9 NESTLES AVENUE, HAYES INITIAL FIRE ENGINEERING REVIEW

EL7233/nh/06th
30 July 2020

This technical note describes the results of an initial fire engineering review of the scheme based on the Draft Plans dated 20 June 2020. The report is intended for design team information to identify the key fire strategy issues at this stage. It is not intended for submission to Building Control.

1 Ground Floor Plan
1 : 100

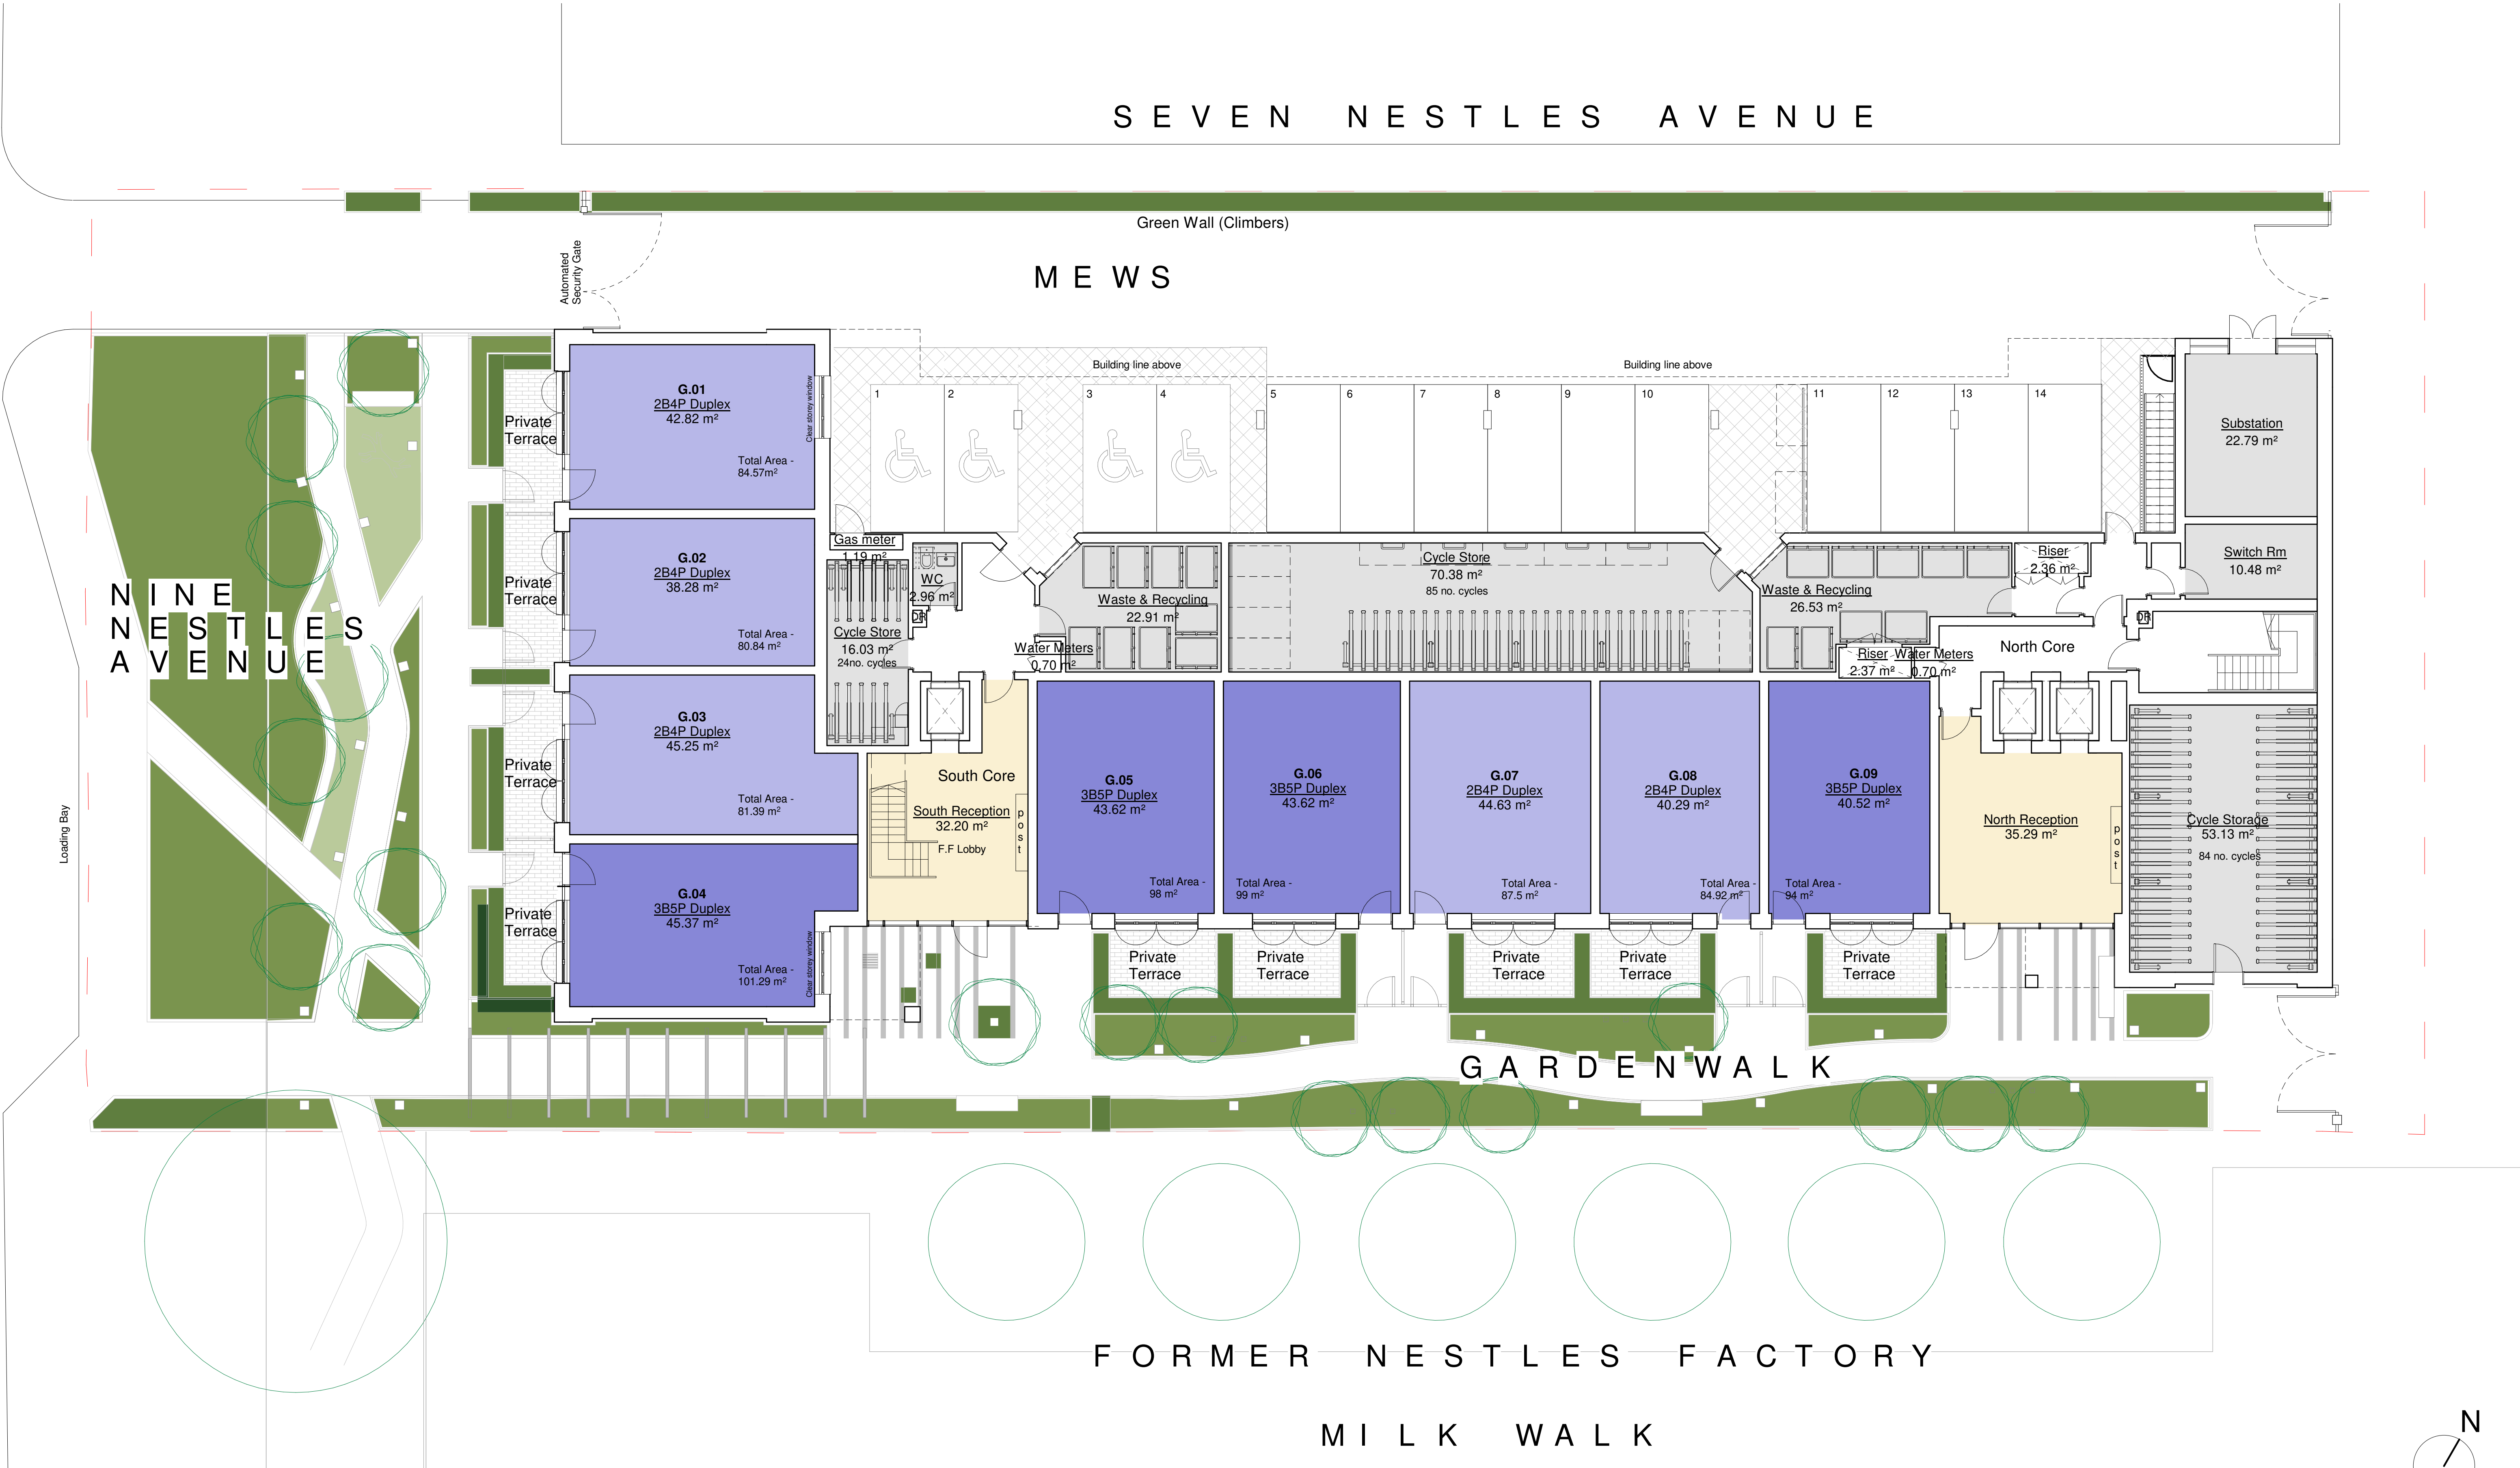
The drawings show the south stair lands directly in the Reception. This is fine, but the reception will need to be kept entirely fire sterile. Fire rated post boxes should be fine.

The mechanical smoke extract shaft serving the upper levels should be extended to serve the corridor between the car park and reception. We recommend allowance for a fire curtain to be provided over the corridor side of the dual entry lift.

The stair connects directly to the cycle storage at ground floor, and has connections via the lift lobby to the Waste & recycling area, as well as a plant room. Connections to these areas don't comply with Building Regulations guidance.

Given the low risk presented by the cycle store, lobby separation should be sufficient, so an additional door should be provided.

The Plant and Waste & Recycling rooms present a much higher fire risk, so additional protection will be needed. At least 2 door separation from the lobby will be needed, and the residential sprinkler system should be extended to serve these areas as well. The Waste & Recycling room may need to be sub divided into separate fire rated compartments depending on the maximum size area the sprinkler system can deal with. Input from the sprinkler designer is needed. If open louvres can be provided from the plant and waste rooms direct to outside then these would provide further protection to the residential escape route to allow smoke and heat to vent direct to atmosphere. Discussion with Building Control is needed.

Fire curtains should be allowed for on the lobby side of the two lifts.

1 First Floor Plan
1 : 100

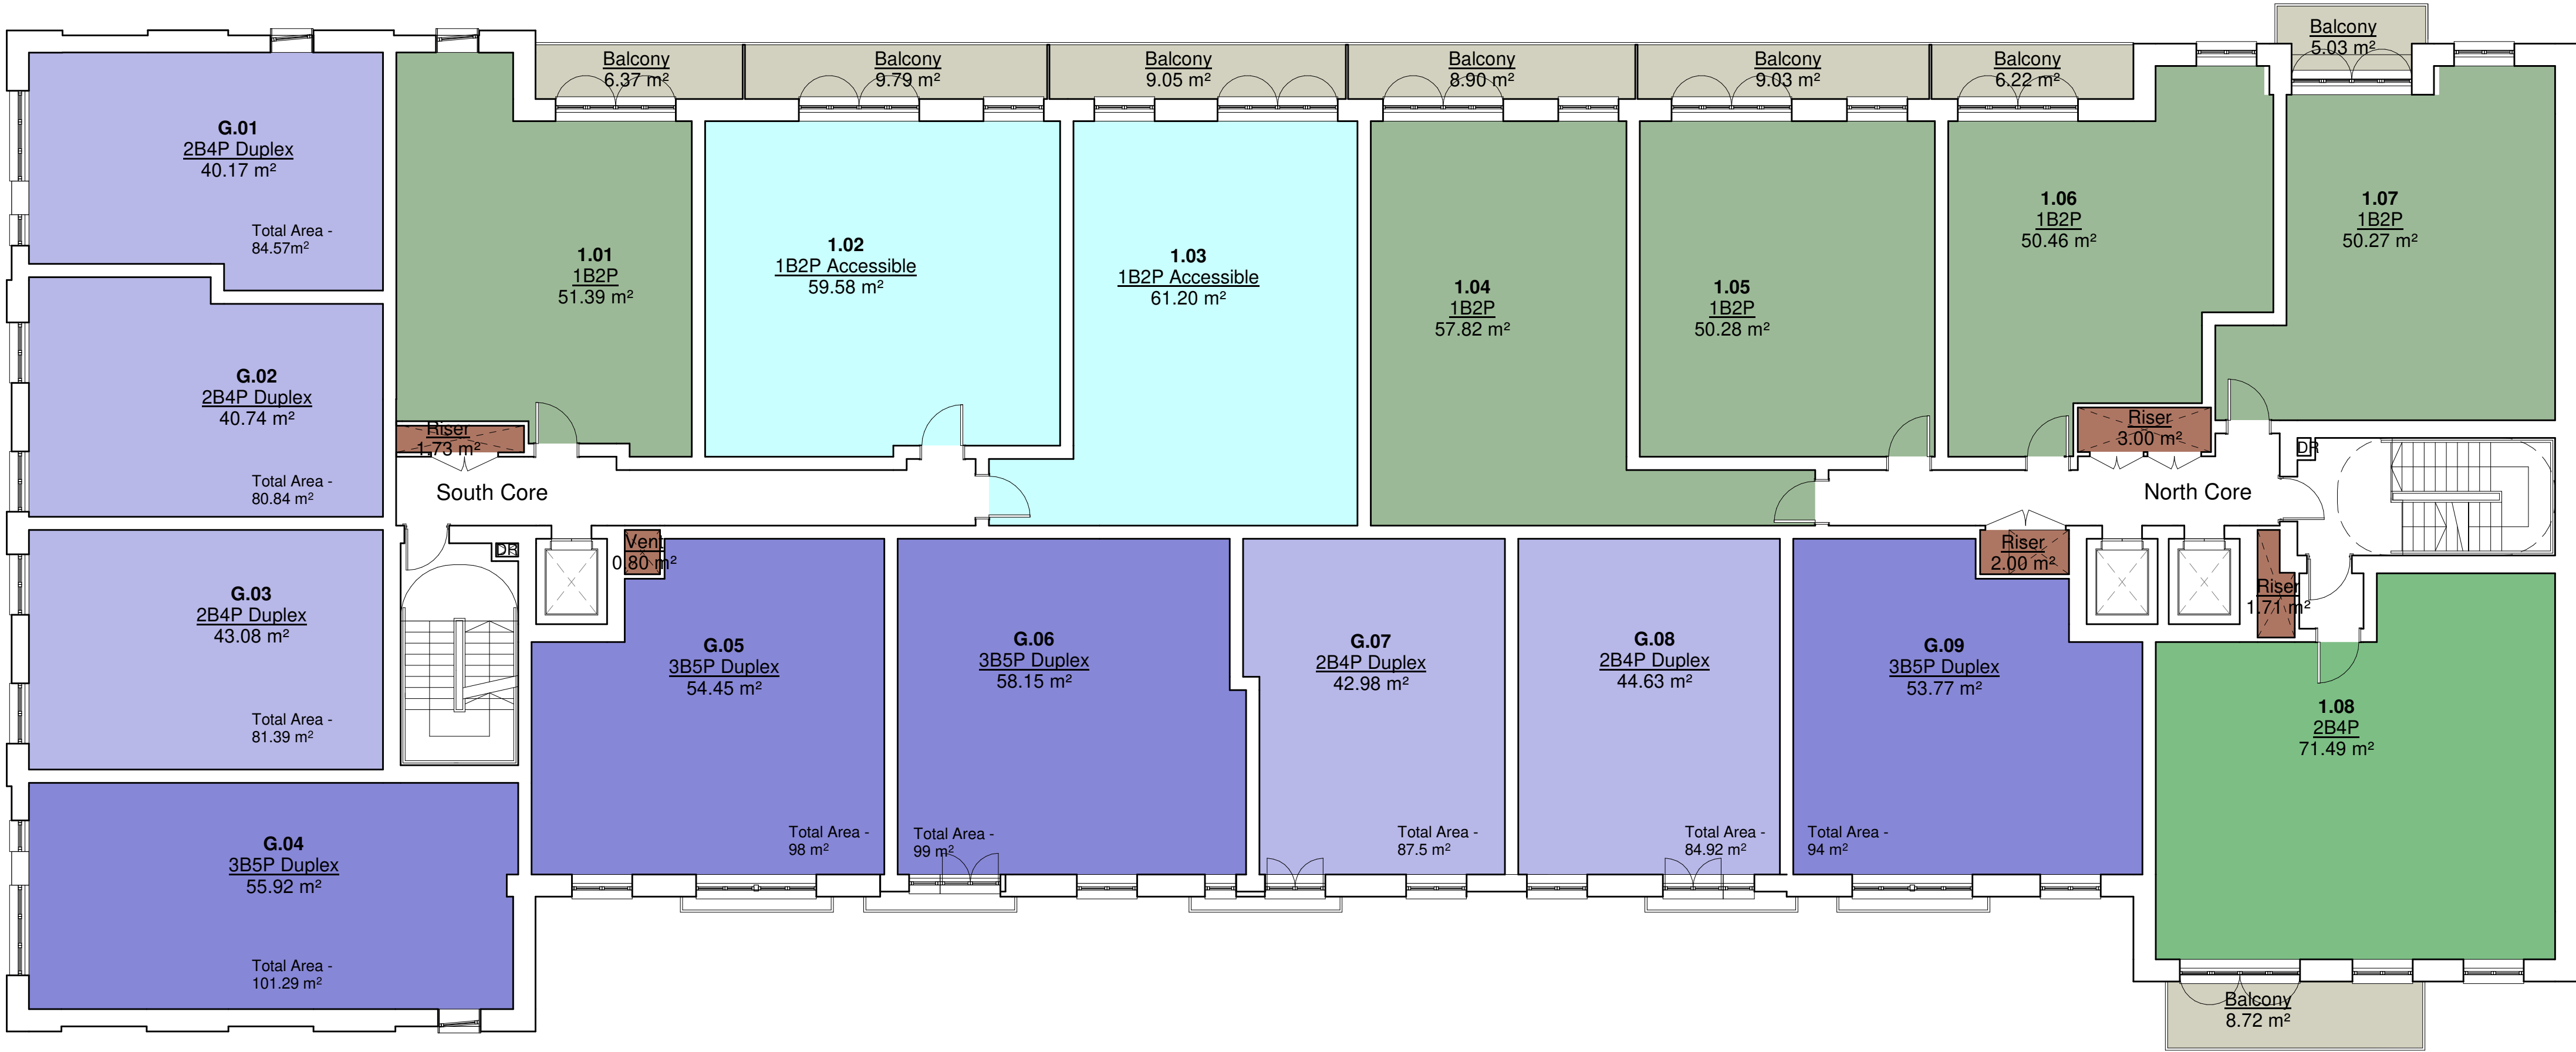
The drawings show the a lift lobby which is separated from the main residential corridor. However, the lift lobby also provides access to apartments, which doesn't work. This is because where lift lobbies are separated from the residential corridor, they should be essentially fire sterile. We recommend that the door separating the lift lobby from the main corridor is omitted at each level so the corridor is a single undivided space.

The drawings also show at each level an apartment adjacent to the lift core which opens into the stair via a small lobby. This can work, but would require the lobby to be smoke vented. A simpler solution would be to reconfigure the lifts so that the apartment exits directly into the main corridor.

The drawings show an apartment entrance immediately adjacent to the stair door. In each case the smoke extract system will work better if the riser and apartment entrance can be swapped round so the smoke shaft is closer to the stair. This will especially help when carrying out the CFD smoke modelling analysis.

The lift lobby door should be omitted at each level to form a single undivided corridor.
